RE: **Shawn McWethy Park – Phase 2A**
Grading Plan
Engineer's Stamp Date: 10/10/17
Hydrology File: J09D023A

Based upon the information provided in the submittal received on 10/11/17 the above-referenced Grading Plan is approved for Grading and Paving Permit.

Re: Shawn McWethy Park – Phase 2A, J09D023A Hydrology Resubmittal

LG101

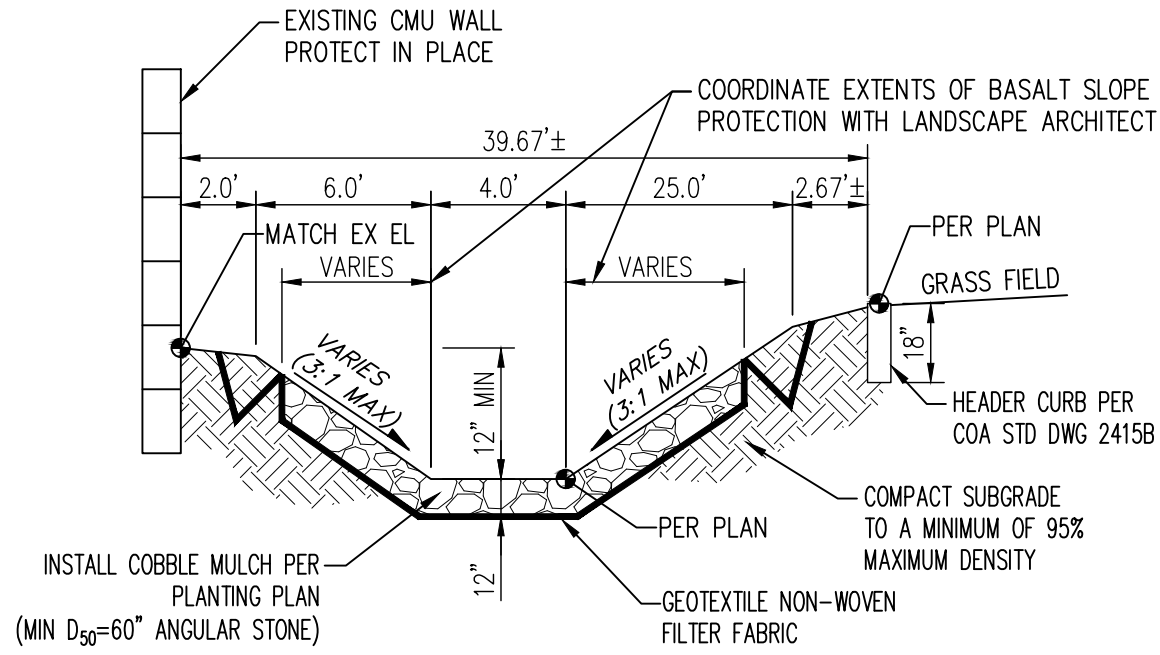
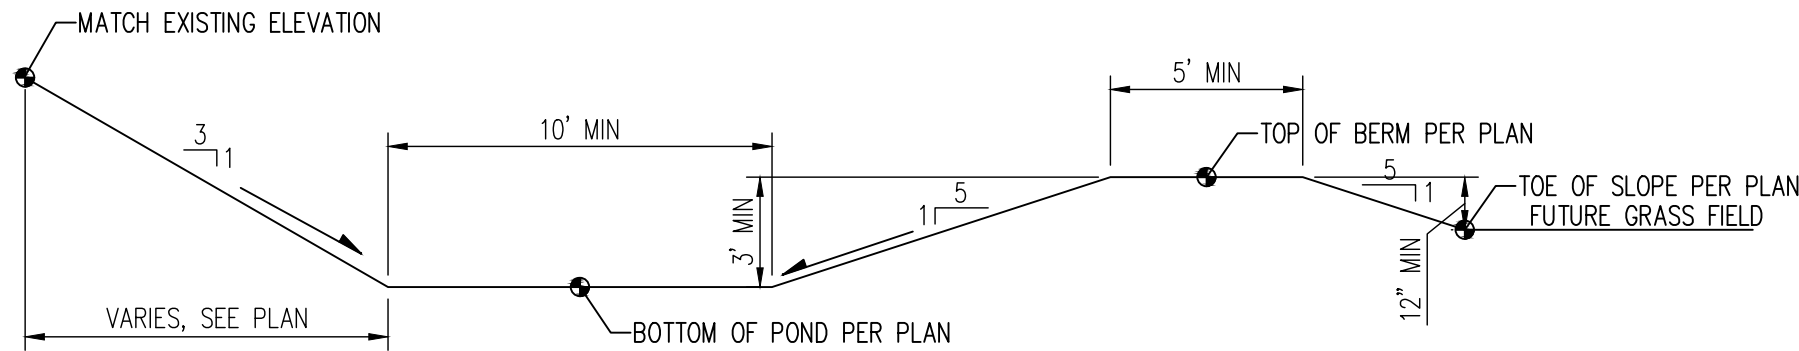
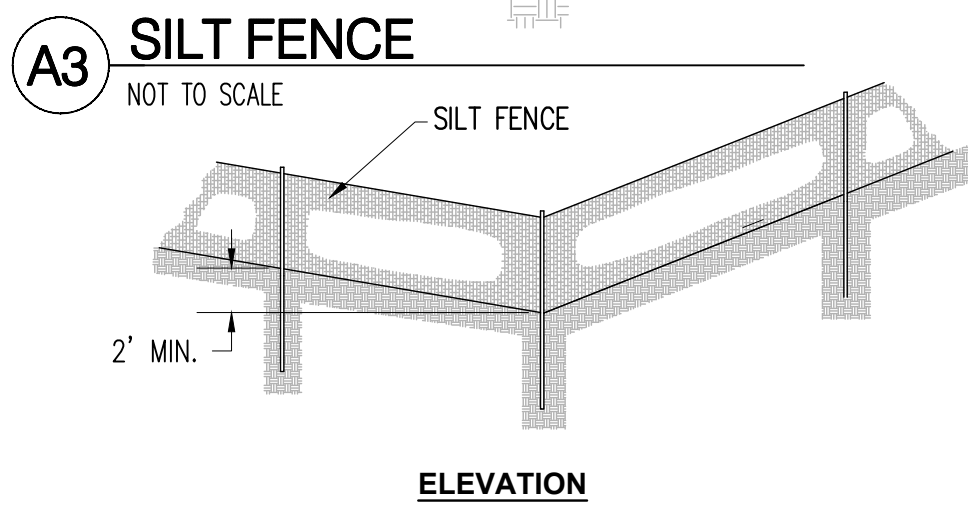
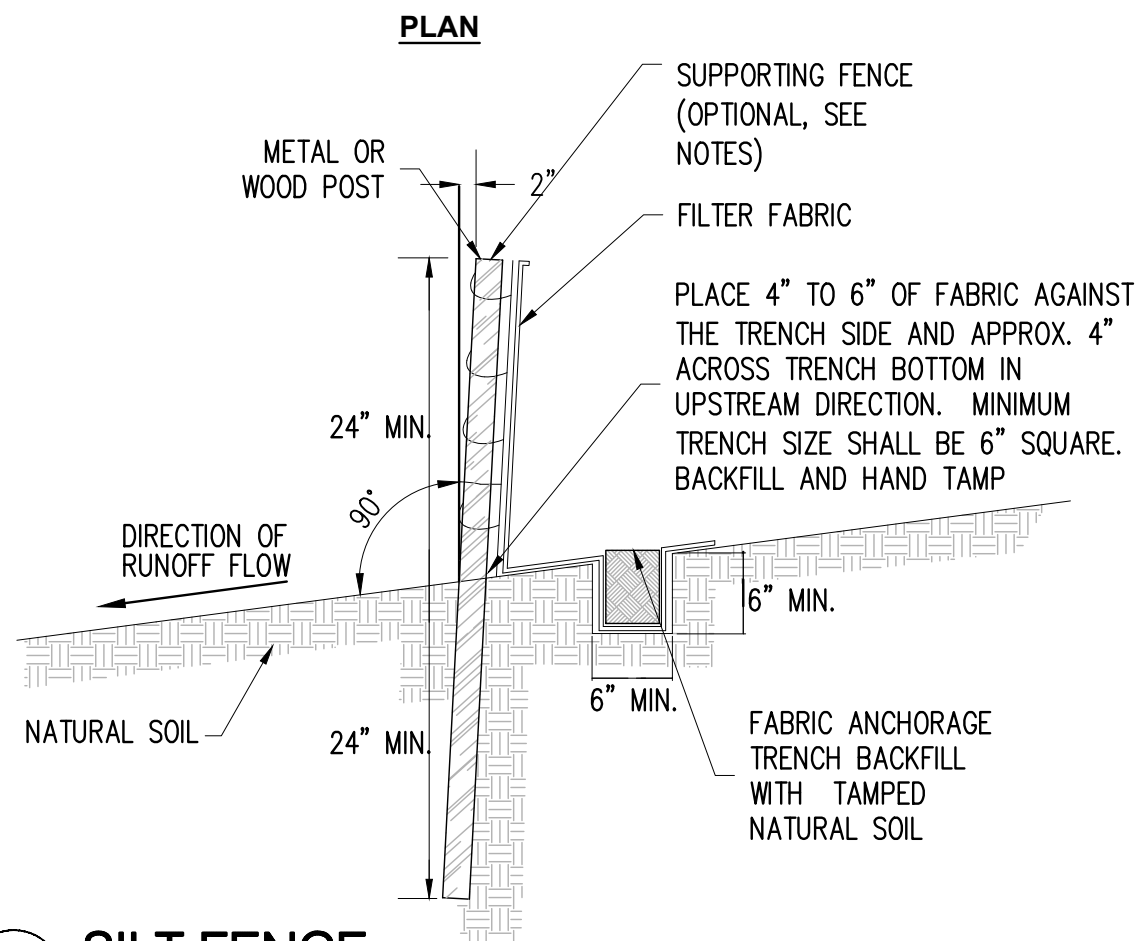
1. The Grading Plans are now stamped.
2. Benchmark and elevation data are now included.
3. The west side desilting swale now includes an armored weir spillway. Calculations for the temporary weir are included as well.
4. The MWSE is now shown.
